From: Bruce Taunton
Sent: 02 September 2014 12:09
To: Planning.Responses
Subject: RE: Planning Consultation on: EG/50/14/PL

APPLICATION EG/50/14/PL
NO:

Site Address: Land at Tars Farm Church Lane Barnham PO22
0BD

Description of Works: Conversion of existing agricultural buildings to form 1 No dwelling house (including feed and equestrian store), 1 No holiday let and associated garaging.

DRAWING TITLE
Ground Floor/ Site Plans As Proposed

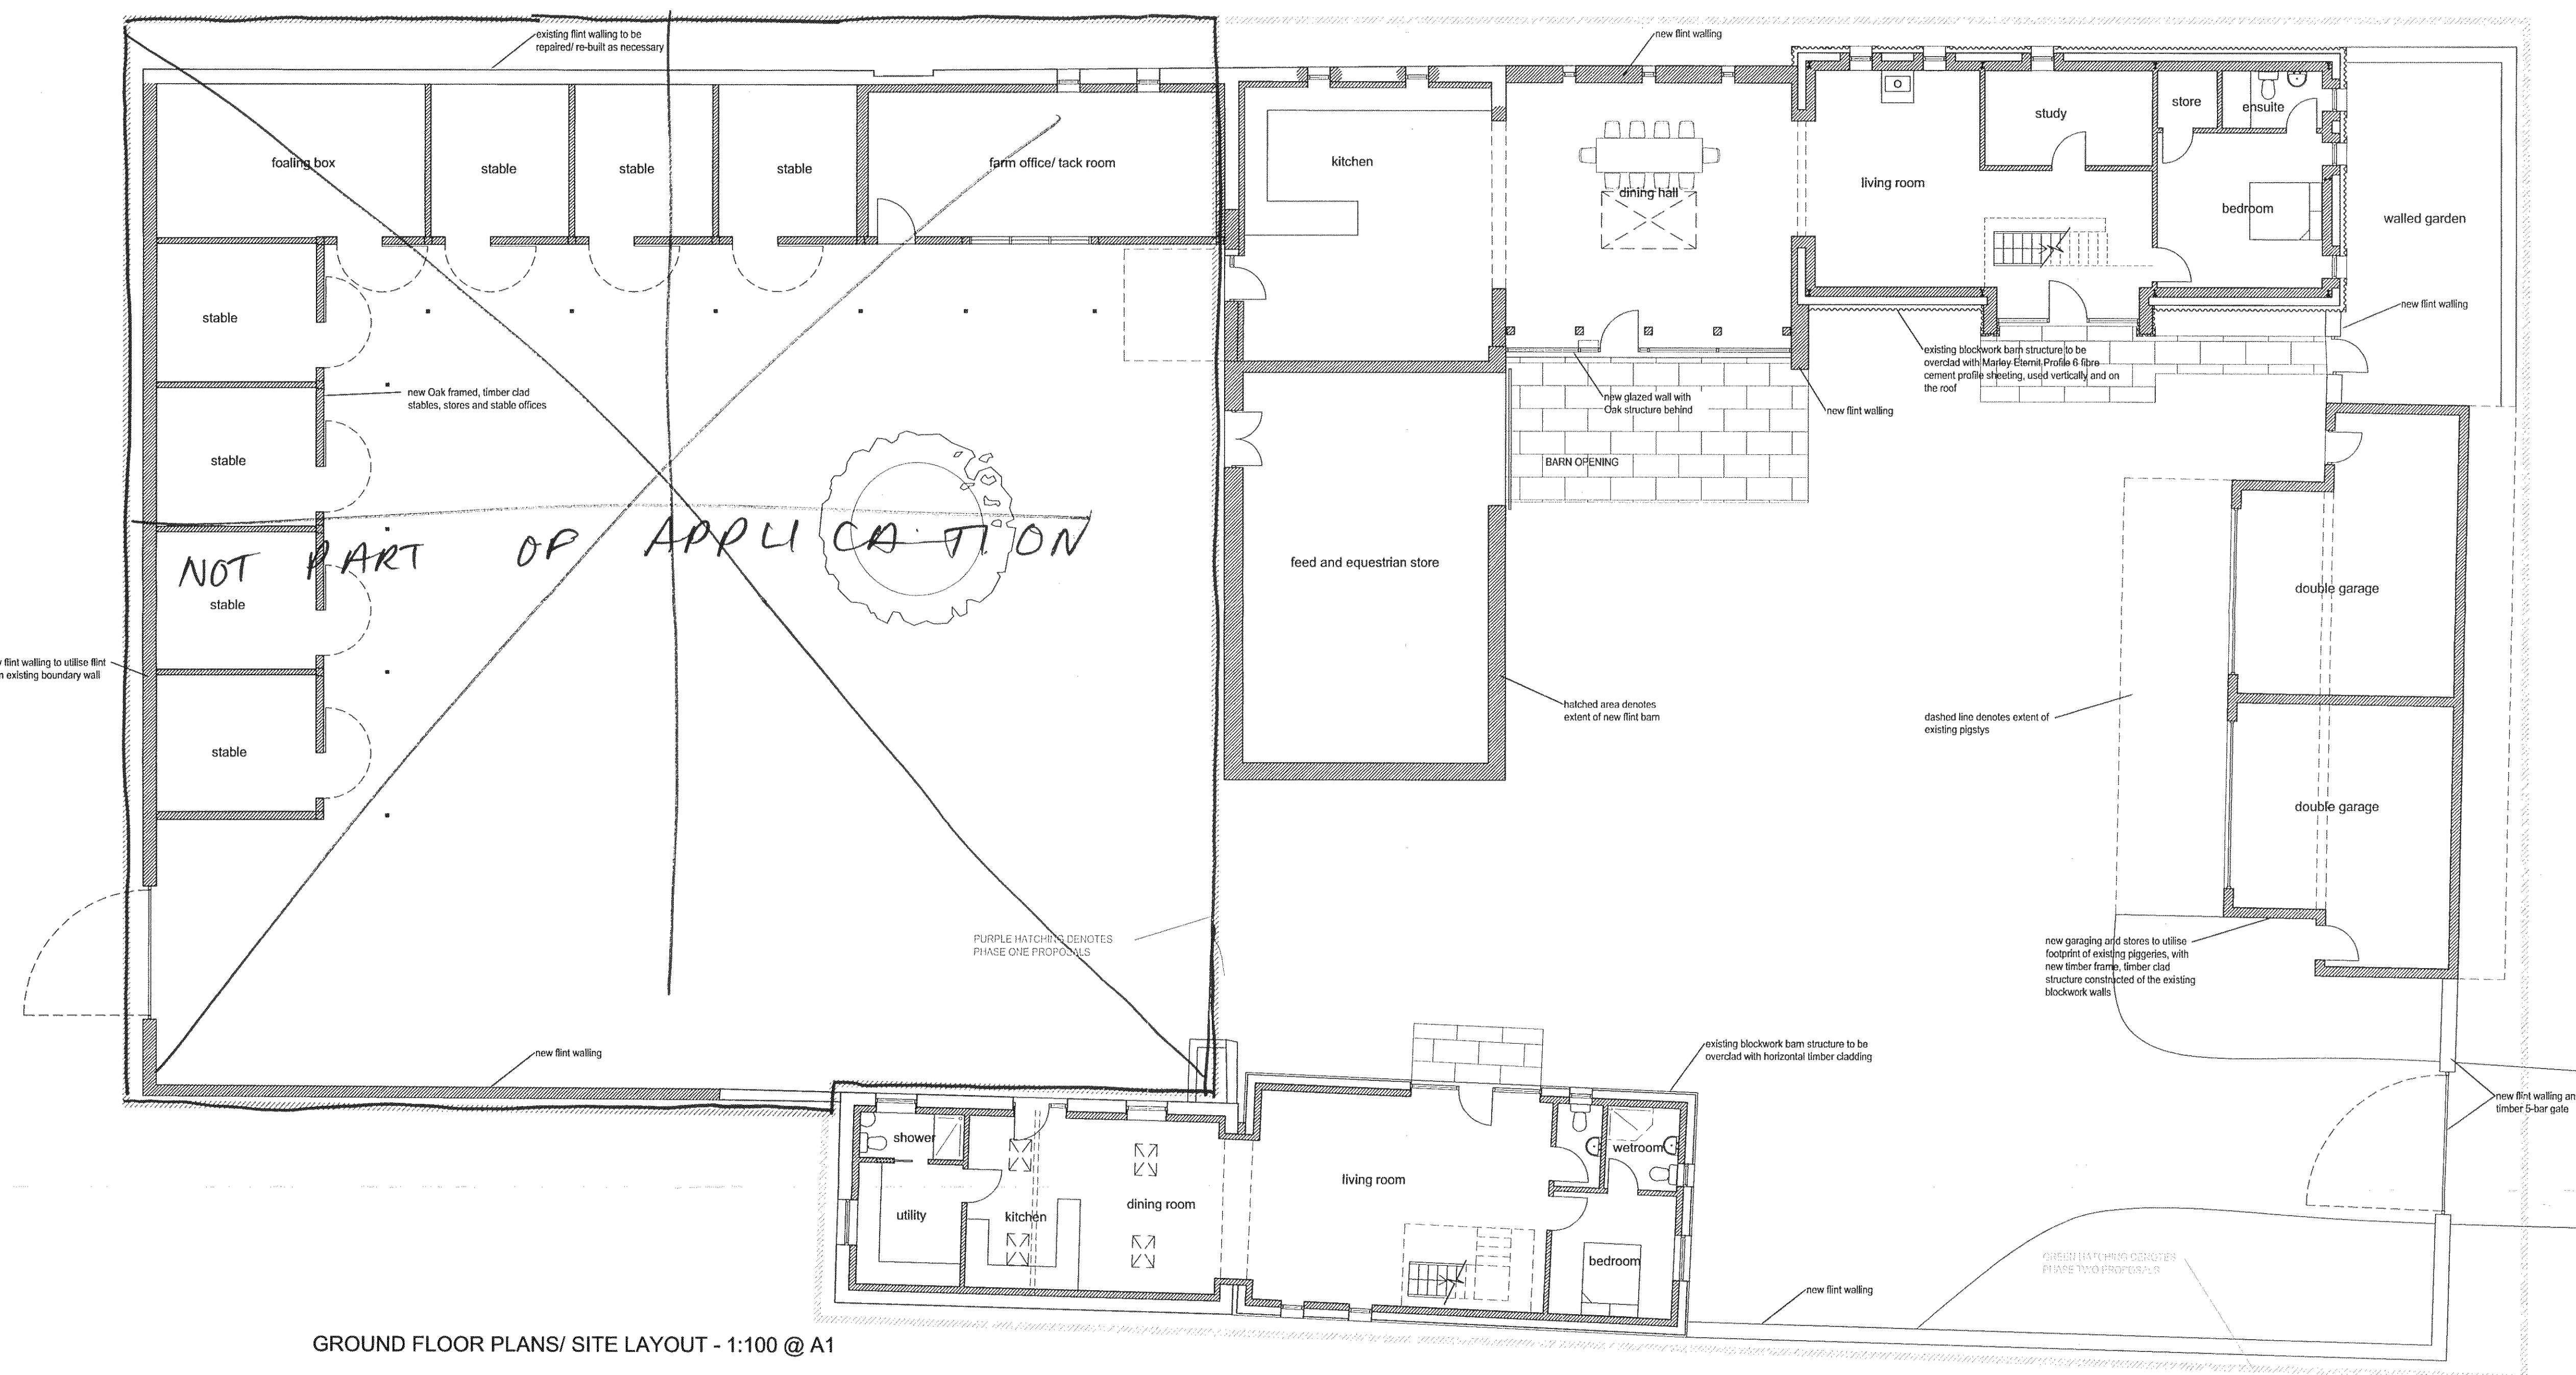
Based upon the information provided there appears to be significant levels of foundation/underpinning and ground floor slab works required to all buildings to enable conversion. Details of how this will be achieved including temporary works to maintain the walls stability during execution of any works should be provided and agreed in principal. (Code ENG52)
